14 March 2012

PEMULWUY MIXED USE DEVELOPMENT, REDFERN (MP06_0101 MOD 1
& MP11_0093)

Basement Level B1

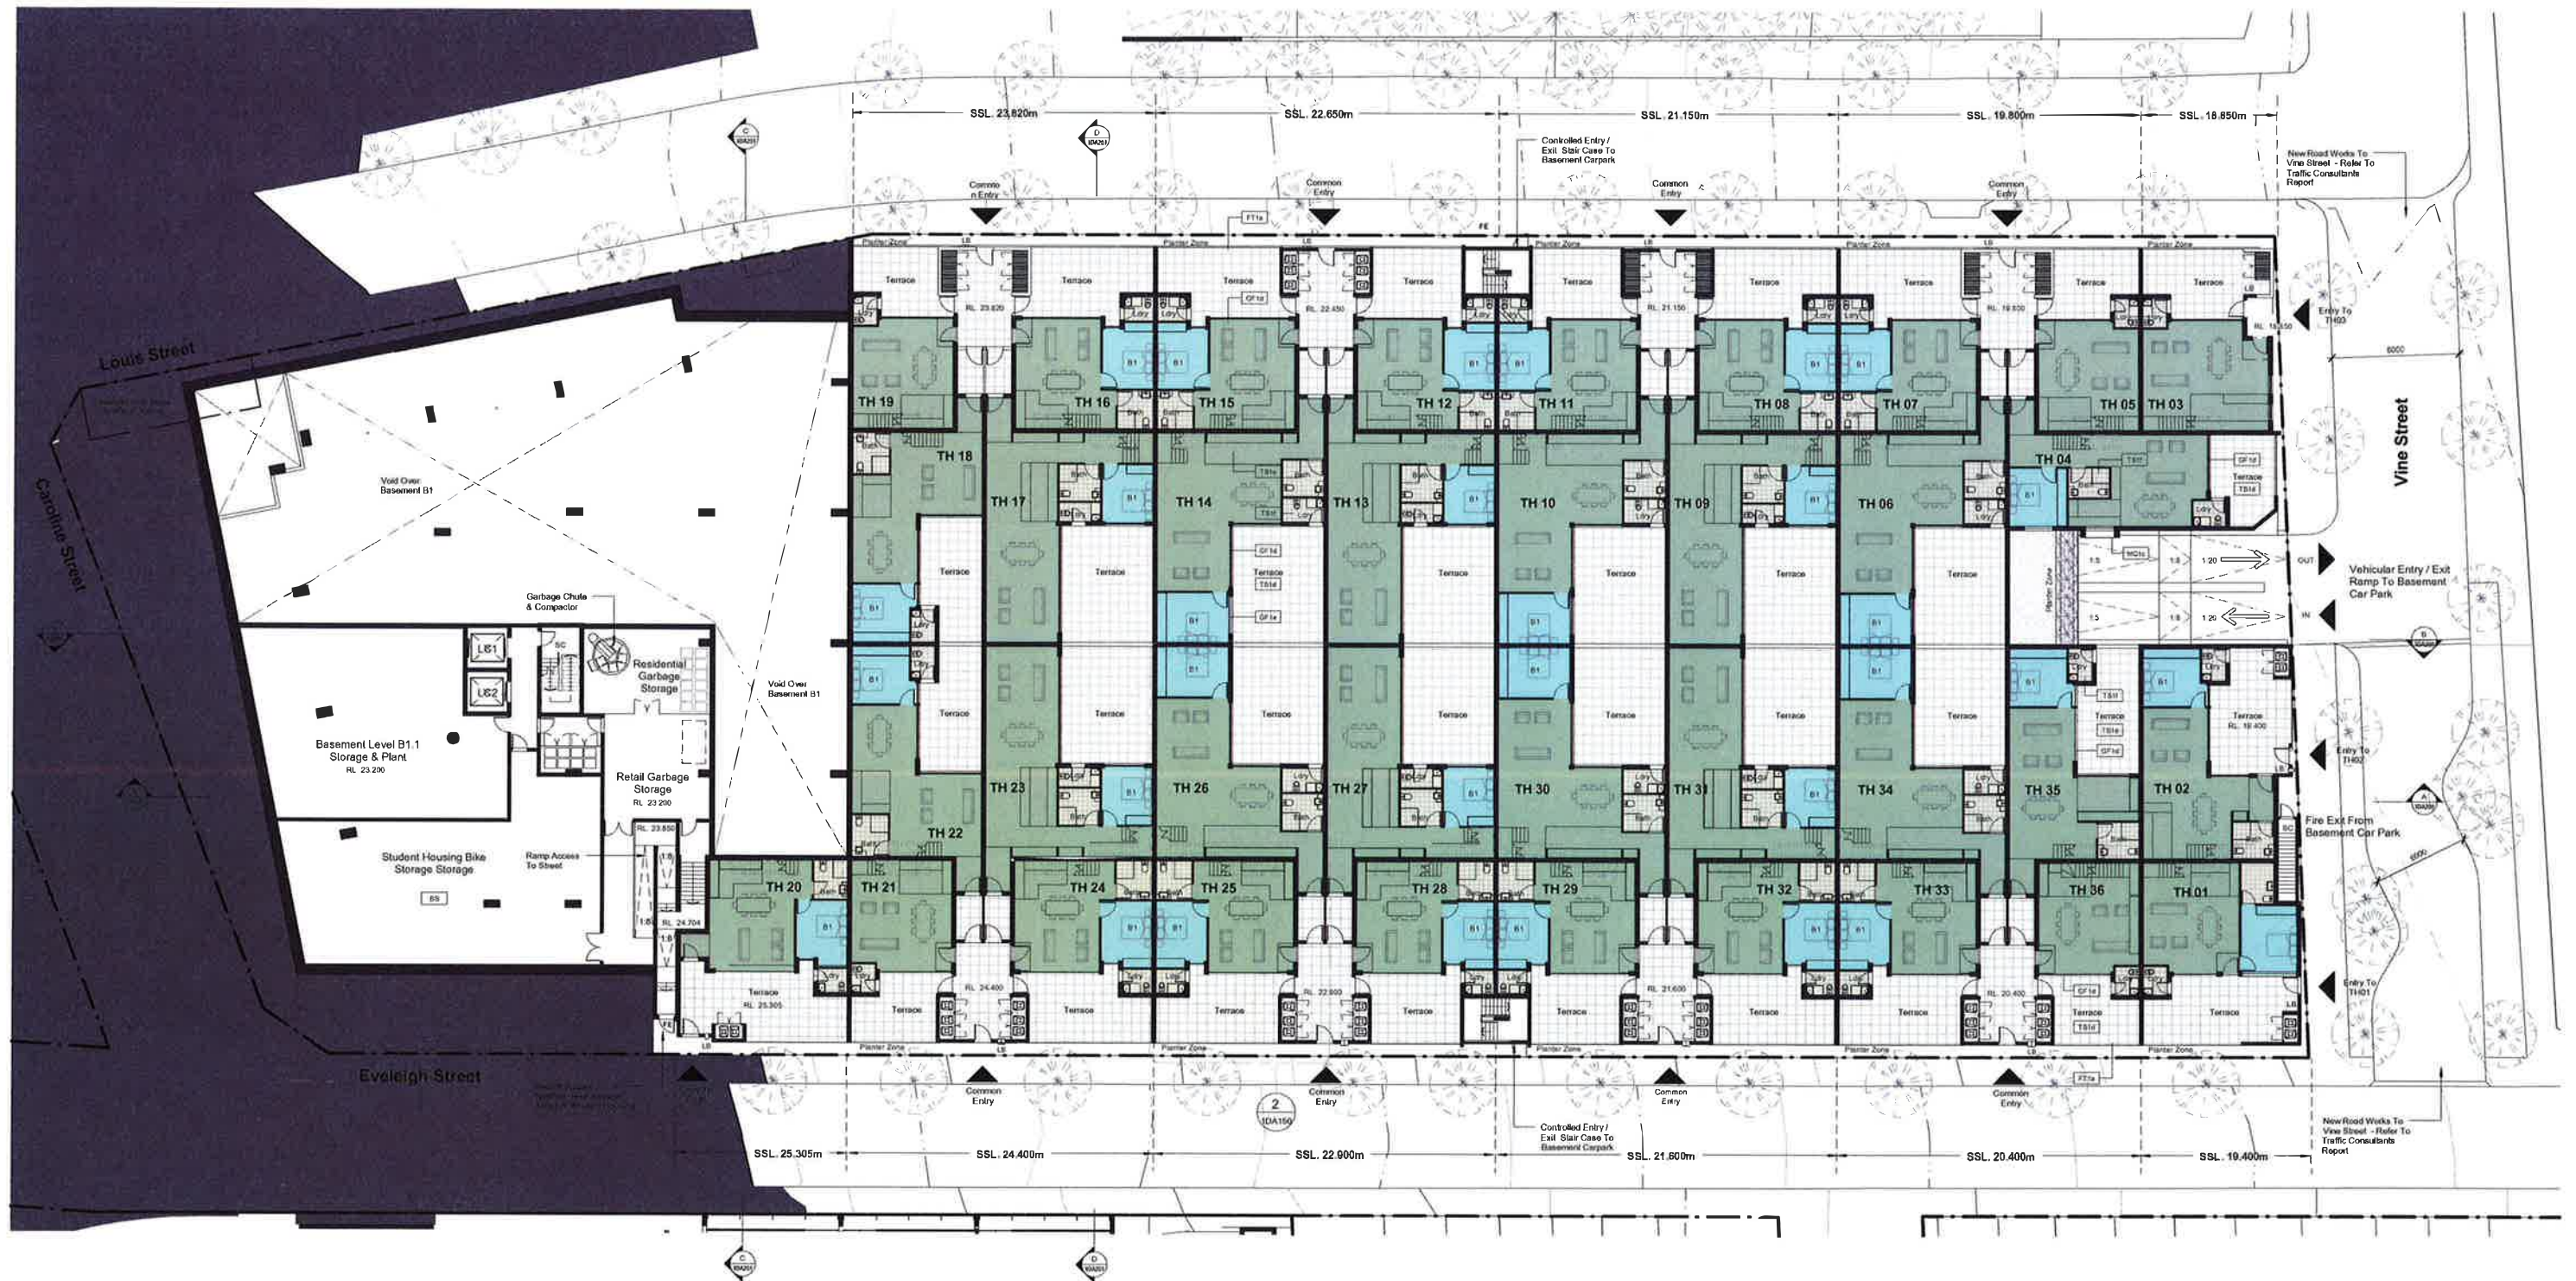
In relation to the proposal, we wish to submit our strong objection to the proposed number of car park spaces (115) and the resulting traffic flows into and out of Vine Street and the adverse impact this will have on traffic flows in Eveleigh Street and the surrounding streets.

The number of proposed off-street parking spaces is excessive and unnecessary due to the development's proximity to public transport options; Redfern station is within walking distance (less than 50 metres) of the development with one of the largest number of services available on the entire Sydney network. It is unjustifiable that so many car park spaces are proposed. We also note the bus services in the area are plentiful and frequent and more
